Recommendation Report for Planning Permission for Works or Extension to a Dwelling

REF NO: FP/143/21/HH

LOCATION: 19 Wordsworth Gardens
Felpham
PO22 6QZ

PROPOSAL: Single storey rear and side extension

sheet 1 of 3

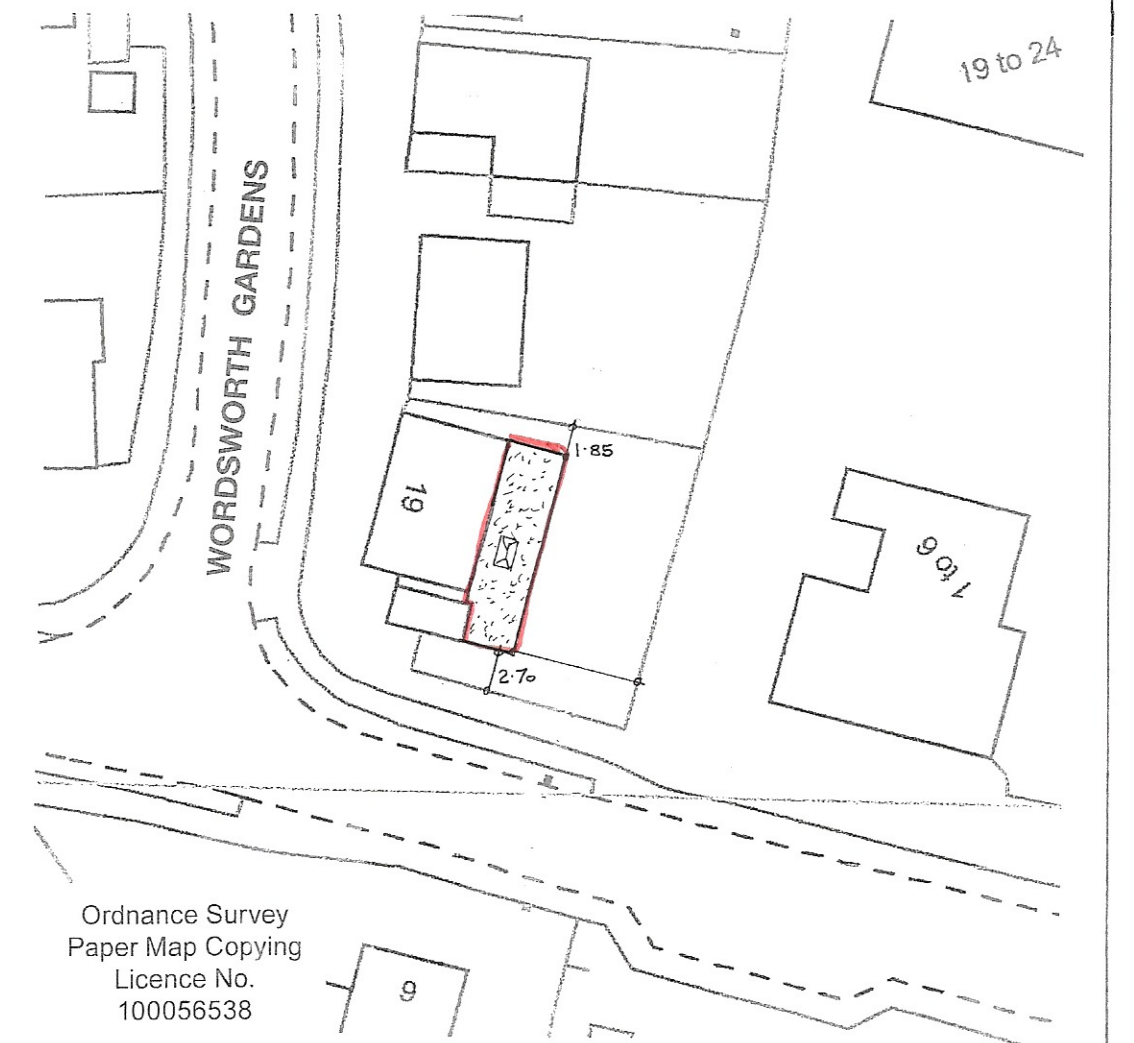
The proposals are for a single storey rear and side extension to the east and south elevations. Due to the siting to rear (east) and side (south) the proposal is restricted from view from street scene and surrounding area so does not adversely impact street scene or surrounding character of area and complies with policy D DM1 of the Arun Local Plan. Whilst the proposal flat roof design does not integrate with the pitched roof design of the dwelling, it is single storey and is visually subservient to main dwelling so is acceptable.

Arun recently adopted a Design Guide. It states development should be subservient to the main dwelling and this complies in terms of scale and size. It states for side extensions, in streets characterised by small gaps between buildings, extensions must not close important gaps in the street scene by leading to a terracing effect, or remove existing external access from front to back gardens. This can generally be ensured by keeping extensions at least 1 metre away from the side boundary of a plot at ground floor. The proposals comply with this.

The proposal will have a width of approximately 14.43m and a depth of approximately 4.05m. The height to top of flat roof will be approximately 2.77m. Due to the siting to rear (east) and side (south) elevations, the proposal will increase risk of overshadowing or overbearing effects to 18 Wordsworth Gardens to north. Being at single storey and gap of around 1.85m remaining to side (north) boundary, a gap of around 3.90m remaining between the extension and the neighbouring building and existing boundary fence to north there is no adverse harm to overshadowing or overbearing effects to north so will comply. Due to a gap of around 8.50m remaining to rear (east) boundary and property to Meadow Court to east set back there is no adverse harm to overshadowing or overbearing effects to east so will comply. Due to the location of road to south there are no direct neighbouring properties to south so no harm to overbearing or overshadowing effects to neighbouring properties to south so is acceptable.

sheet 2 of 3

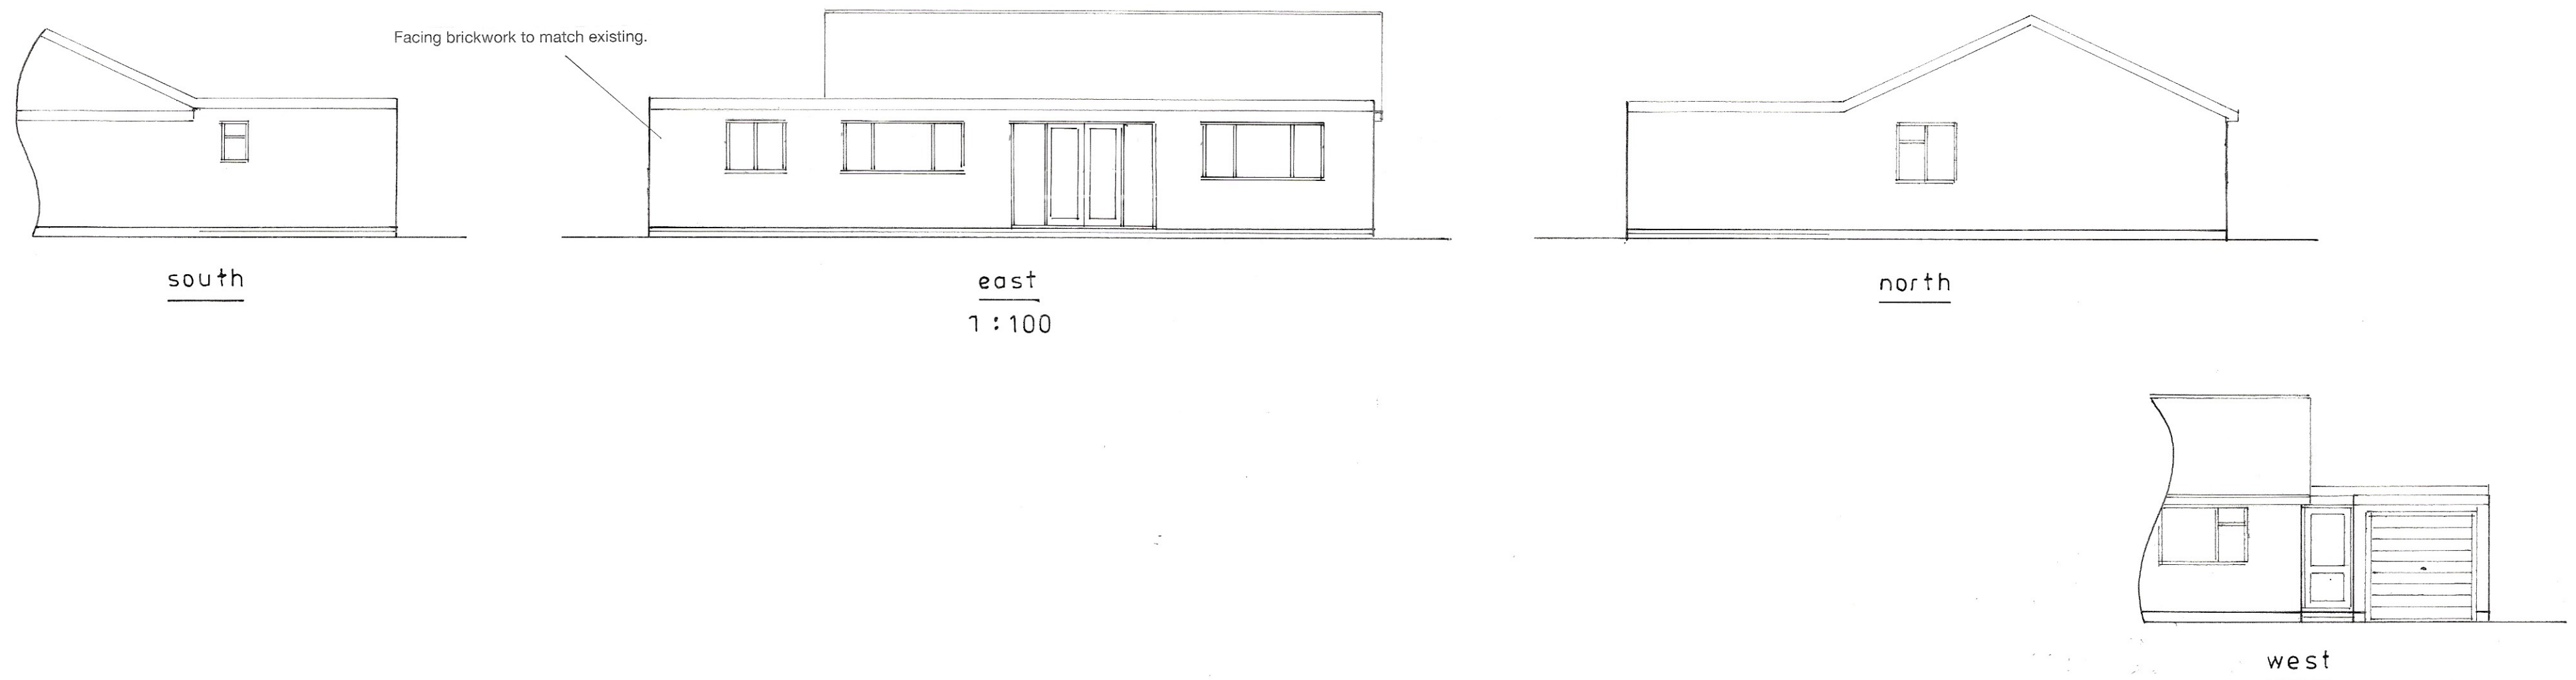
The proposal will have a width of approximately 14.43m and a depth of approximately 4.05m. The height to top of flat roof will be approximately 2.77m. There will be one new set of double doors with side window panes, one new window (2 window panes) and two large windows (3 window panes) to rear (east) elevation. There will be one new single door to front (west) of side extension facing the drive to the front. There will be one new single window to side (south) elevation and one new single roof light to south centre of roof plane.

There will be one new window (2 window panes) to side (north) elevation of existing property.

Due to the one new set of double doors with side window panes, one new window (2 window panes) and two large windows (3 window panes) to rear (east) elevation there is increased risk to overlooking to neighbouring properties to rear (east) however due to large gap of around 8.50m remaining to rear (east) boundary and neighbouring property Meadow Court to east set back there is no adverse harm to overlooking to neighbouring property to east. Due to building line to north set back there is no adverse harm to overlooking to neighbouring property to north so is acceptable.

Due to the one new single window to side (south) elevation there is increased risk to overlooking to neighbouring properties to the south however due to no direct neighbouring properties due to road to south and existing boundary fence to south there is no adverse harm to overlooking to neighbouring properties to south so is acceptable.

Due to the one new door to front (west) of side extension there is increased risk to overlooking to neighbouring properties to front (west) however due to road and no direct neighbouring properties to front (west) there is no adverse harm caused.

Due to the one new window (2 window panes) to existing side (north) principal elevation of existing property there is increased risk to overlooking to neighbouring property number 18 Wordsworth Gardens to north however due to being at single storey, location of existing boundary fence to north and gap of around 1.42m remaining to north side boundary there is no adverse harm to overlooking effects to neighbouring property to north so will is acceptable.
